WEST SUSSEX COUNTY COUNCIL CONSULTATION

TO:	Arun District Council FAO: Finlay Gardner
FROM:	WSCC - Highways Authority
DATE:	28 May 2021
LOCATION:	339 Chichester Road, Bersted, PO21 5AN
SUBJECT:	BE/59/21/PL Replacement of blockwork boundary wall with fence and new vehicular access (resubmission of BE/149/21/PL.
DATE OF SITE VISIT:	N/A
RECOMMENDATION:	Advice
S106 CONTRIBUTION TOTAL:	N/A

SITE PLAN - SHOWING VISIBILITY SPLAYS
1:500 SCALE (at A3)

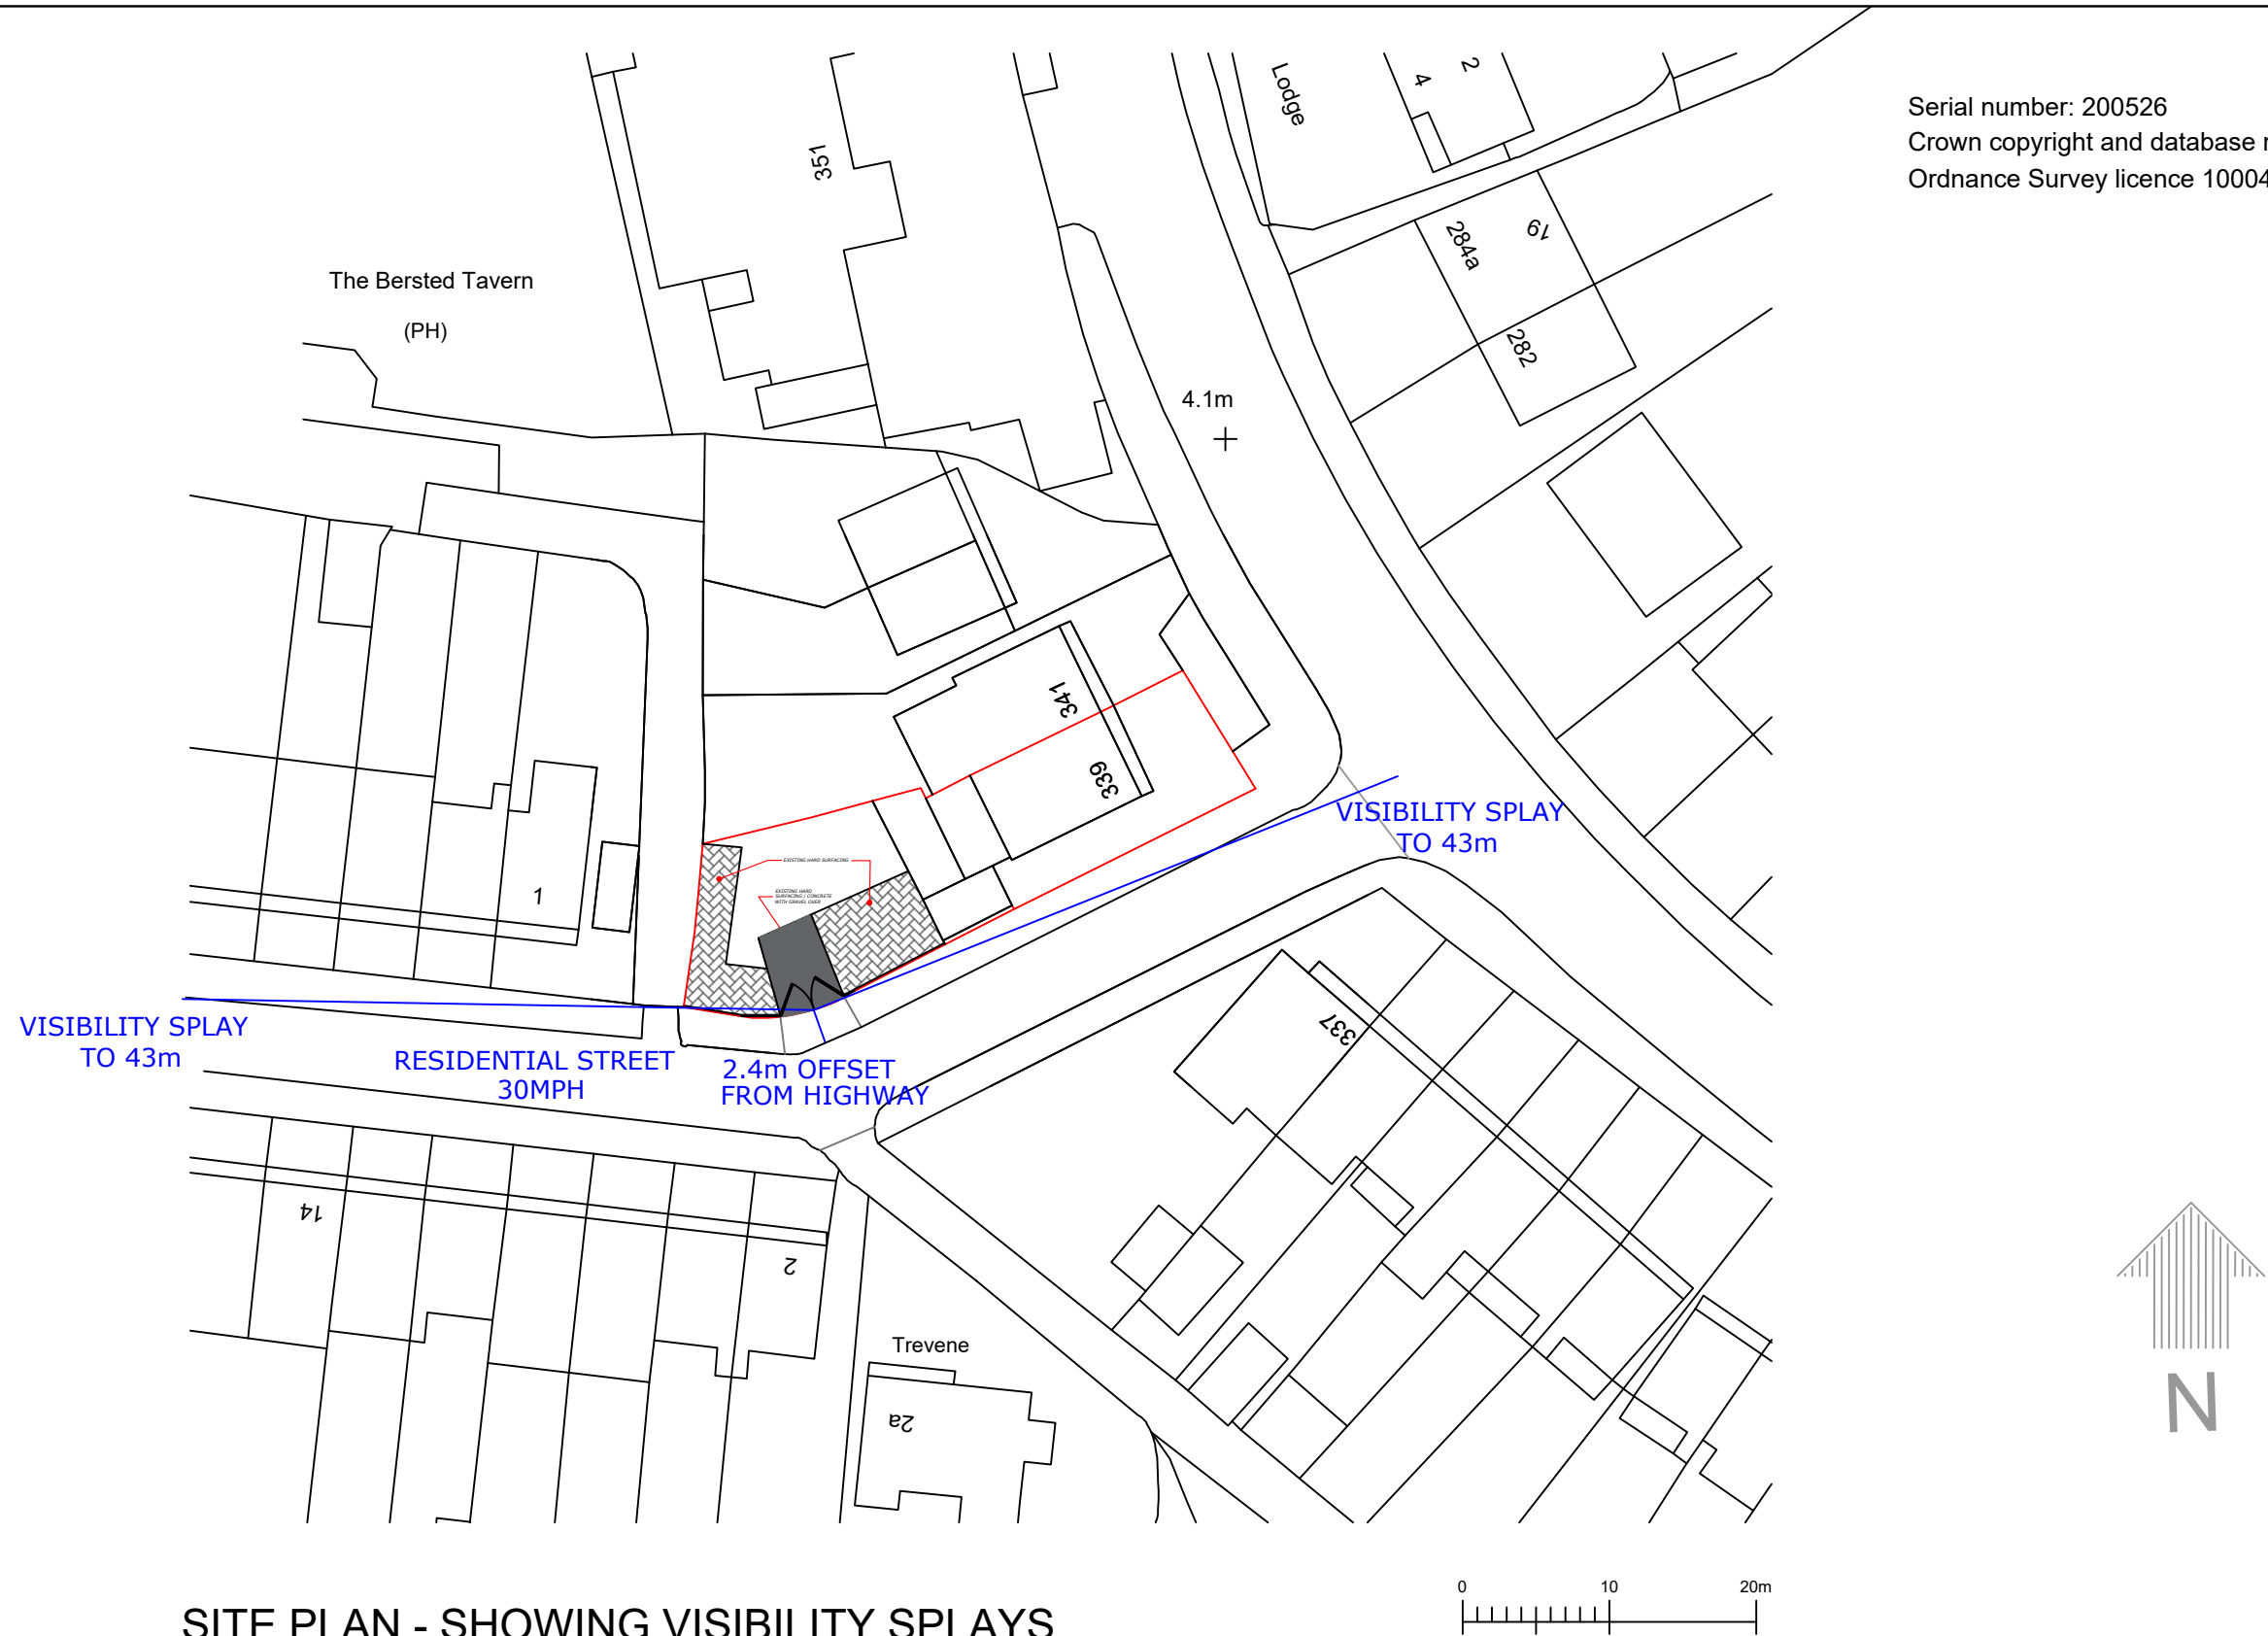
As Bedford Avenue is subject to a speed restriction of 30 mph, Manual for Streets (MfS) is the standard for vehicular visibility in this location. This sets out a minimum stopping sight distance of 43m in each direction, set back 2.4m from the back edge of the carriageway. The applicant has submitted a site plan demonstrating visibility splays to this requirement. These splays shall thereafter be kept clear of all obstructions to visibility above a height of 0.6m above the adjoining road level, and this can be secured by condition.

The LHA does acknowledge written representations, highlighting that on-street parking occurs close to the proposed access. 10.7.1 of MfS states that parking in visibility splays in built up areas is quite common, yet it does not appear to create significant problems in practise. The absence of wide visibility splays at minor accesses will encourage drivers to emerge more cautiously, similarly to how vehicles emerge onto the highway when visibility along the carriageway is restricted.

The applicant has demonstrated the proposed parking area, with provision for four car parking spaces. From inspection of the plans, the parking area is suitably sized for the proposed parking provision. In addition, there is adequate space for on-site turning to be achievable, allowing cars to exit the site in a forward gear.

No use of the access shall take place until such time that visibility splays of 2.4 metres by 43 metres have been provided at the proposed site vehicular access onto Bedford Avenue in accordance with the approved planning drawings. Once provided the splays shall thereafter be maintained and kept free of all obstructions over a height of 0.6 metre above adjoining carriageway level or as otherwise agreed.
